Demolition of existing building & erection of 1 No. 3 bed town house (resubmission following LU/164/16/PL). This application affects the character & appearance of the Littlehampton Seafront Conservation Area & may affect the setting of a listed building.
2A Norfolk Road Littlehampton

Thank you for your internet representation made on 3rd July 2019 which has been recorded as '**no objection**' with the comments as follows:

Project		
2A NORFOLK ROAD		
Status		
PLANNING		
Drawing		
SIDE ELEVATION (NORTH)		
Drwg No :	Scale :	Date :
381_20_231	1:50@A3	27/04/19

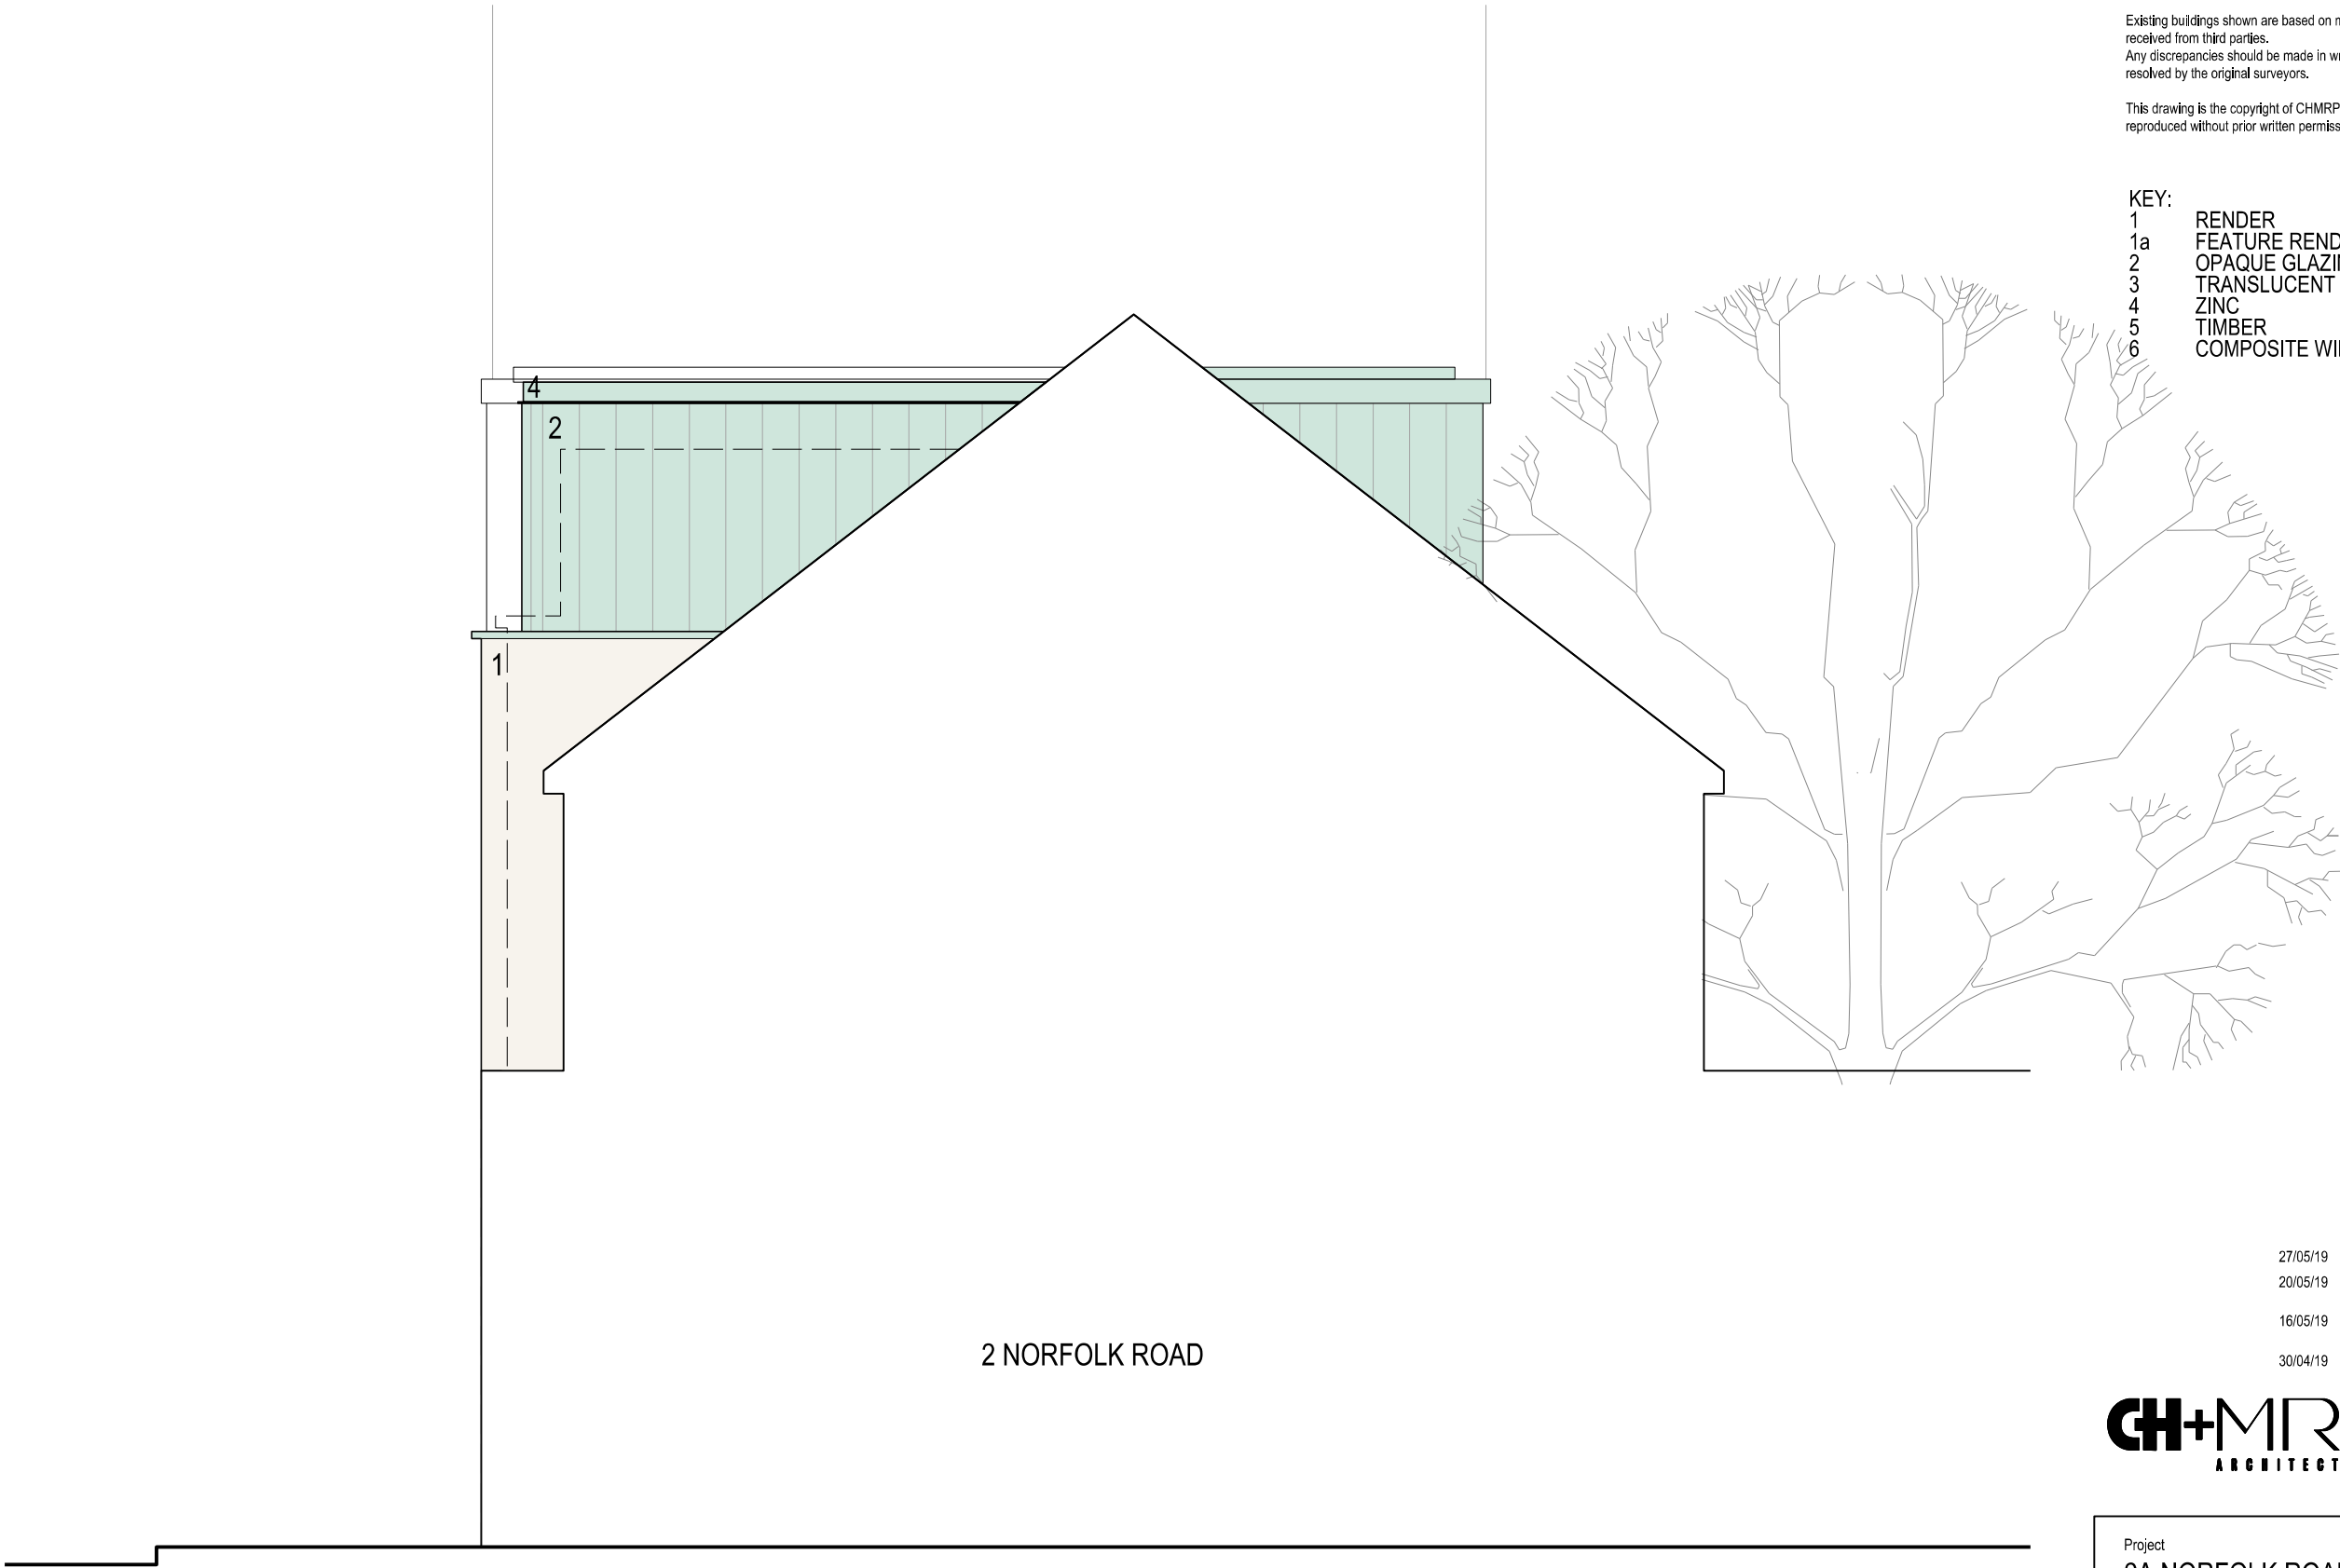
We welcome a well executed contemporary design on the site. The quality of detailing is critical to the success of the proposal. Conditions should be attached to any planning approval requiring precise details of the fenestration and finishes. This should involve large scale drawings to at least 1/10 scale. Samples of materials to be submitted to the planning officer.
